From: [REDACTED]
To: [Longfield Solar Farm](#)
Subject: Ref LOSF-001 Longfield Solar Farm
Date: 02 November 2022 14:37:11
Attachments: [IMG_0185.jpg](#)
[Untitled attachment_00010.txt](#)

I refer to the Applicants Document ref Longfield Solar Farm Works Plan 1 of 2 Doc Ref EN 010118/APP/2.2(B) Revision 3 dated October 2022 and made available on your website Documents 07 October 2022. Page 7 of 9 work Plan.

I have attached to this mail an extract of Page 7 which relates to locations ;Stocks Farm , Stocks Cottages and Little Holts on the Waltham Road.

TITLE: Works Plan Sheet 5

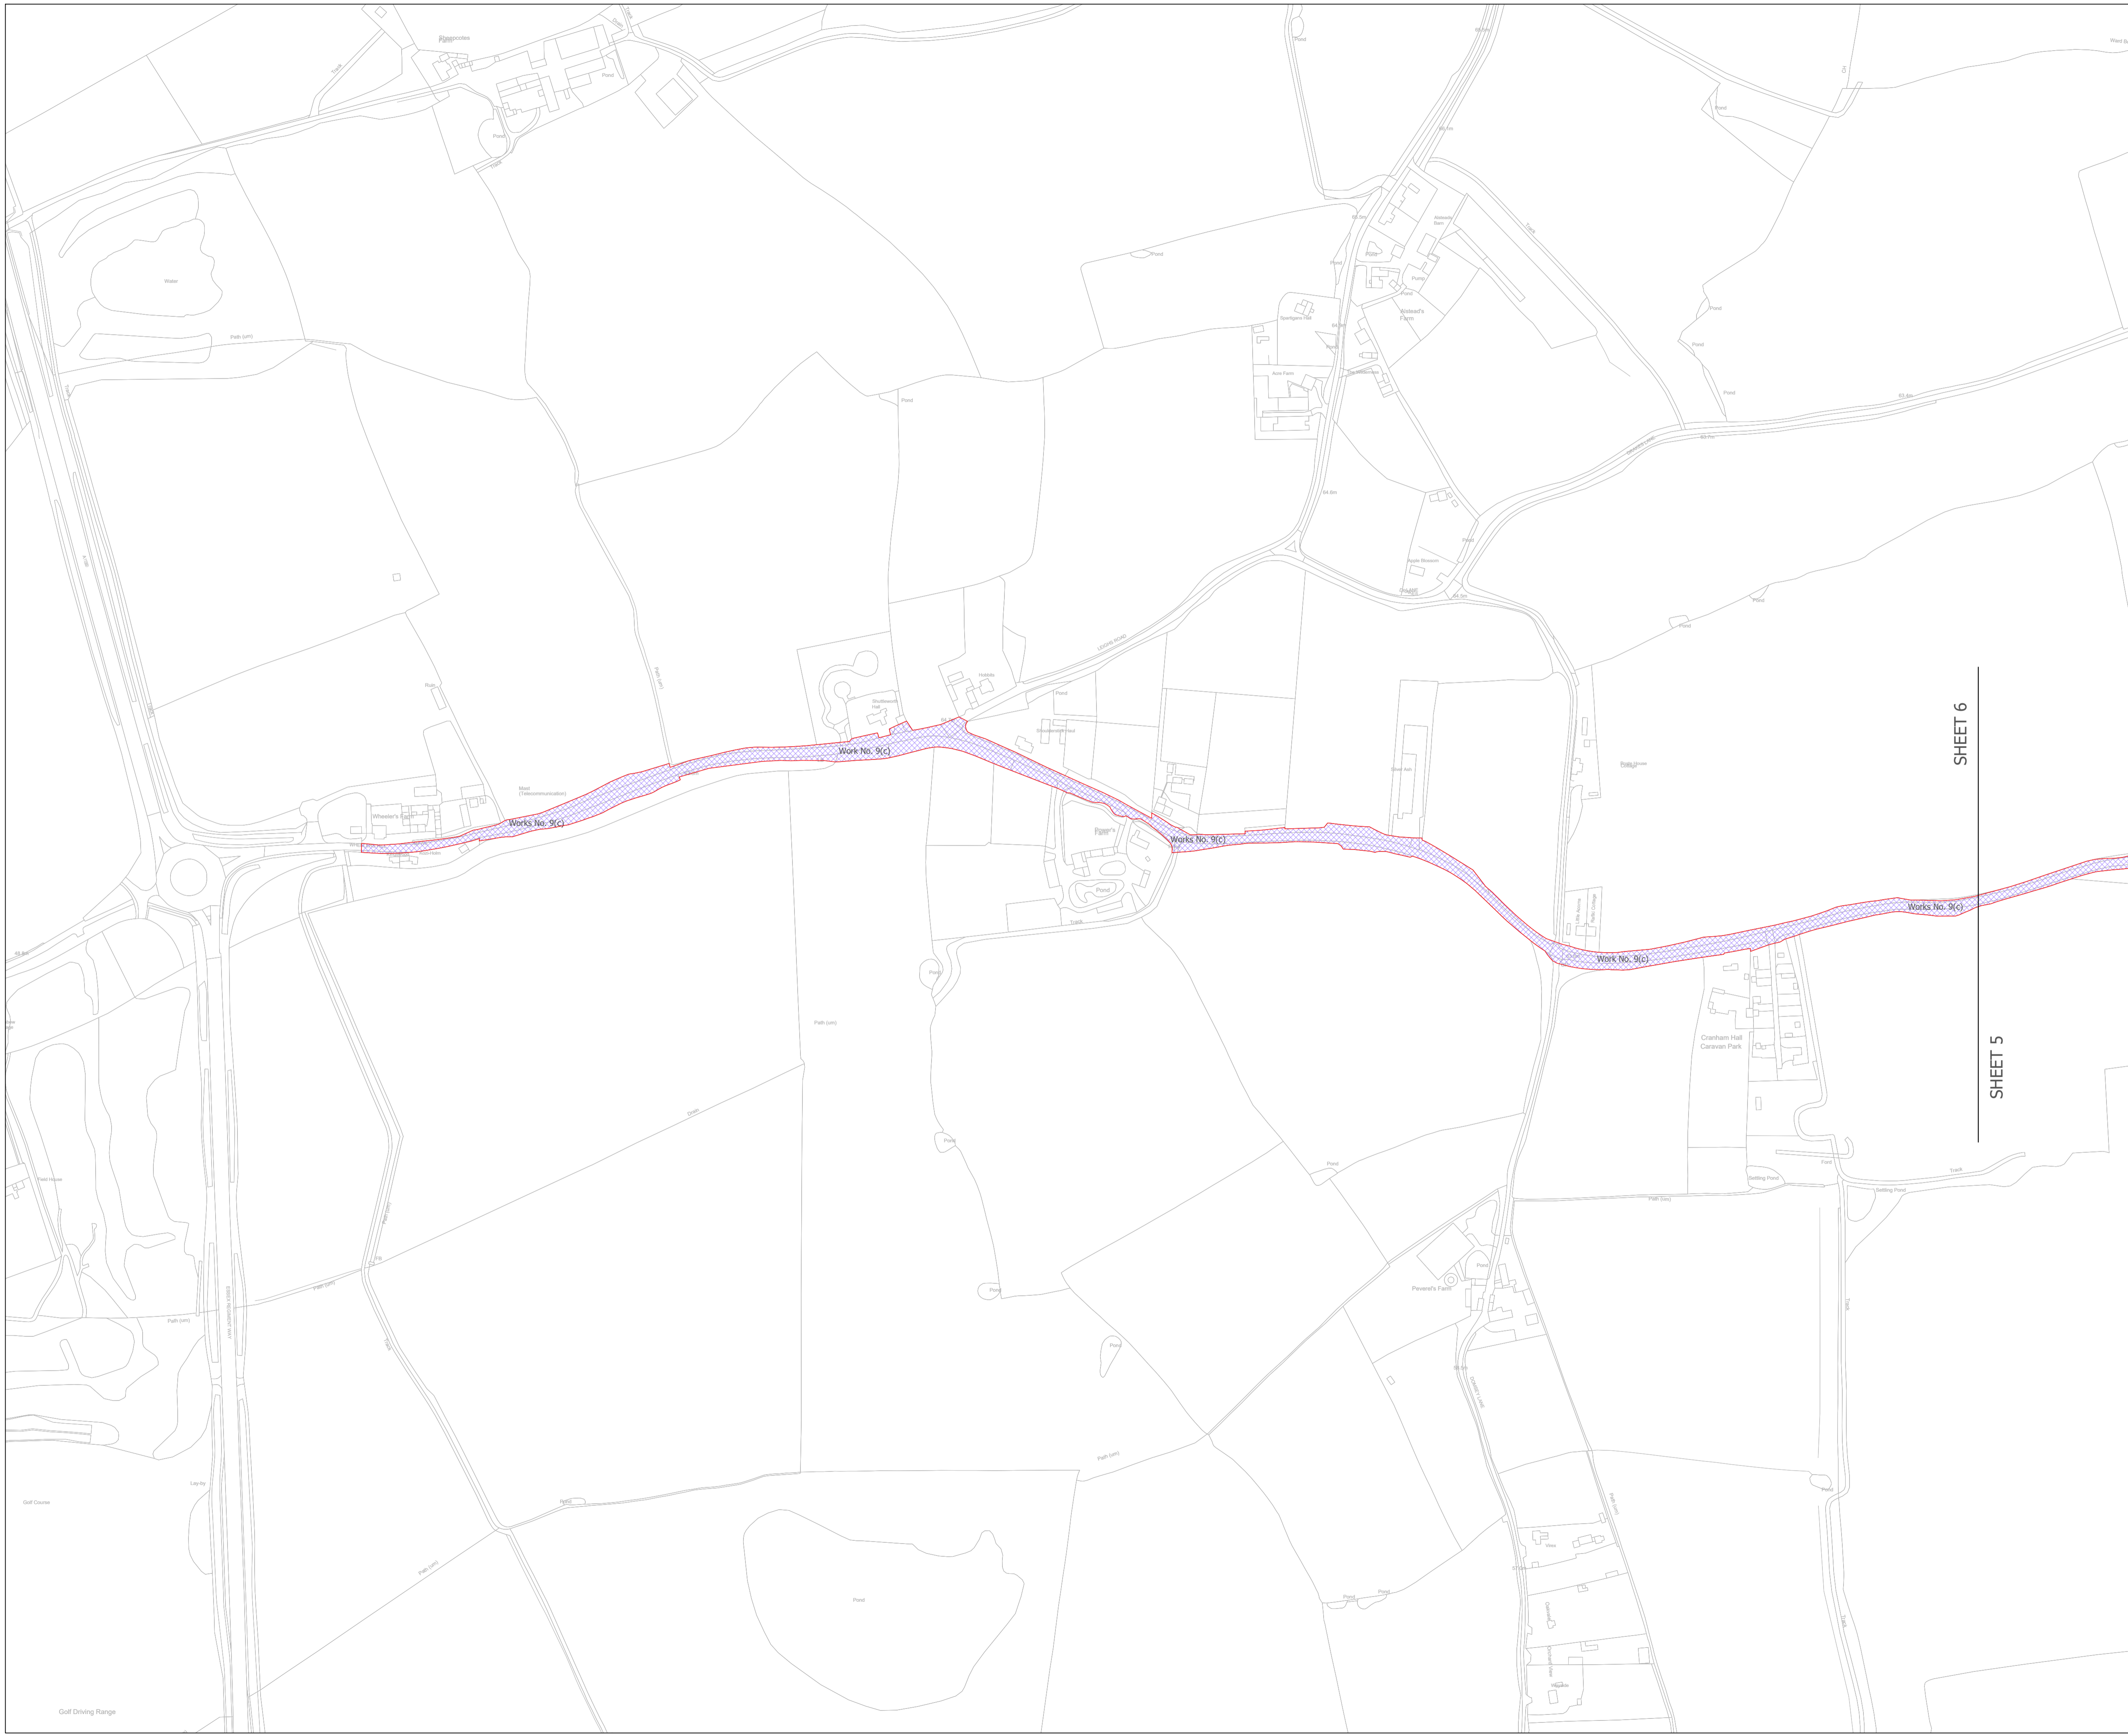
If I understand this plan/map correctly, it would appear that the Applicant has increased the extent of the set aside / buffer zone around Stocks Cottages.

However this still presents significant harm to the amenity and outlook from No 1 Stocks Cottages.

You will see from the attached extract I have inserted a "Blue line" where Mr Bentley feels that the set aside/buffer zone should extend around his property in order to mitigate the impacts of this proposed scheme.

I would be grateful if this could be taken into account when you examine the Applicants proposals.
